Householder Application for Planning Permission for works or extension to a dwelling

Number	21
Suffix	
Property Name	
Address Line 1	Bishops Road
Address Line 2	
Address Line 3	Hillingdon
Town/city	Hayes
Postcode	UB3 2TB

To erect a 1.8 metre wooden fence on the outside boundary which is next to the pavement of Bishops Road. To increase security and privacy.

PROJECT	REVISIONS	SITE	PROJECT NO:	SHEET TITLE	CLIENT
2m High Fence		21 BISHOPS ROAD HAYES UB3 2TB	215F as shown @A3	PROPOSED ELEVATIONS DATE DEALT AW CHECKED AW	Mr Hossein Meshkat

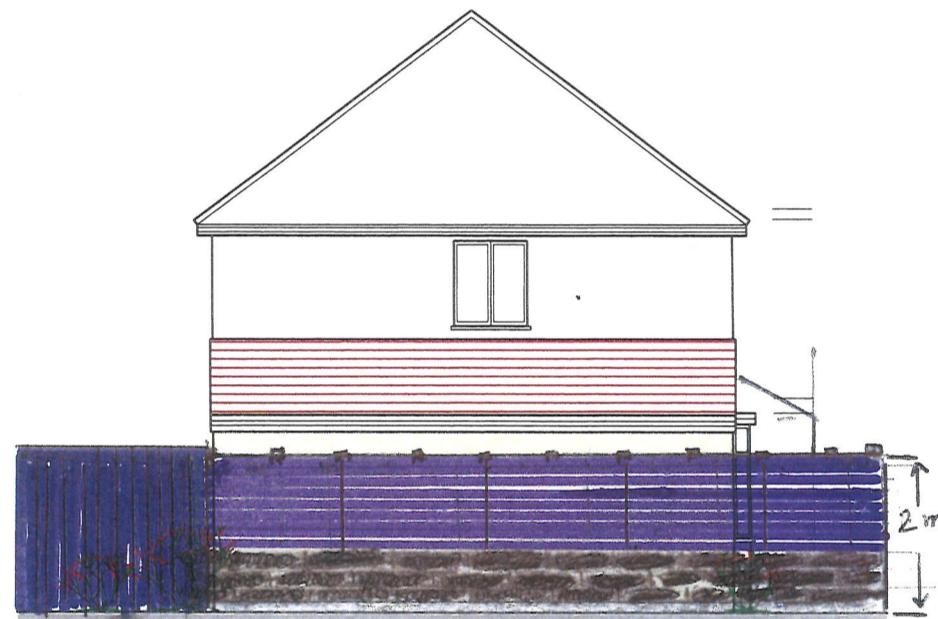
Please alter the height from 2 metres to 1.8m
